Submission for Job: #7056 Remediation, Restoration and Adaptive Re-Use of Campbell's Stores
https://majorprojects.affinitylive.com/?action=view_job&id=7056

From: [REDACTED]
Sent: Monday, 7 December 2015 1:02 PM
To: Ashley Cheong
Subject: Remediation, Renewal and Adaptive Re-Use of Campbell's Stores, The Rocks. SSD 7056

Re: Re-Use of Campbell's Stores, The Rocks. SSD 7056

03 NORTH ELEVATION
SCALE: 1:200

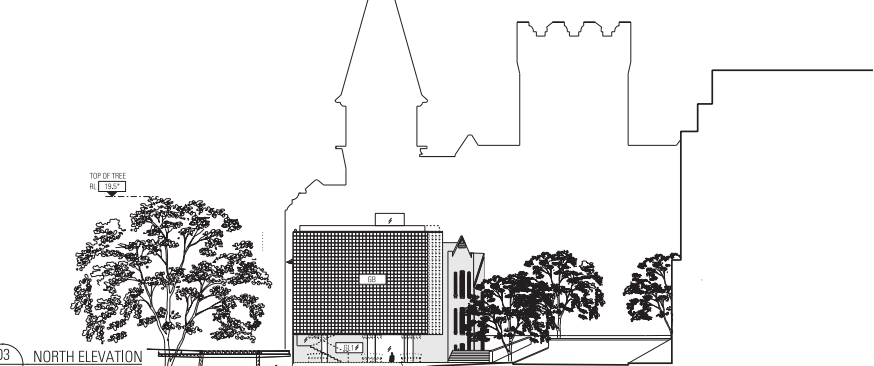
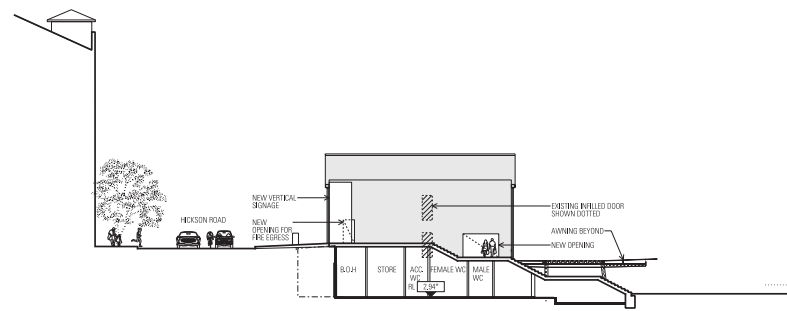
- * Locating the new glass box in place of the existing intrusive structure to the north of the Stores, will obscure views of the northern elevation of Bay 11 and destroy the opportunity for people to appreciate Campbell's Stores' historic significance as a stand-alone industrial building within its maritime setting. This would be particularly the case when the building was viewed from the north, including from the northern end of Hickson Road, from the pedestrian pathway on the eastern side of the Sydney Harbour Bridge and Dawes Point Park when it is reopened for public use on completion of the Harbour Bridge restoration work (see Photomontages 6a and 7a).

- * The basement level of the proposed glass box will abut the ground level of Bay 11 effectively burying the northern elevation of the classified 'Highly Significant' heritage façade to approximately top of door height on the ground floor.
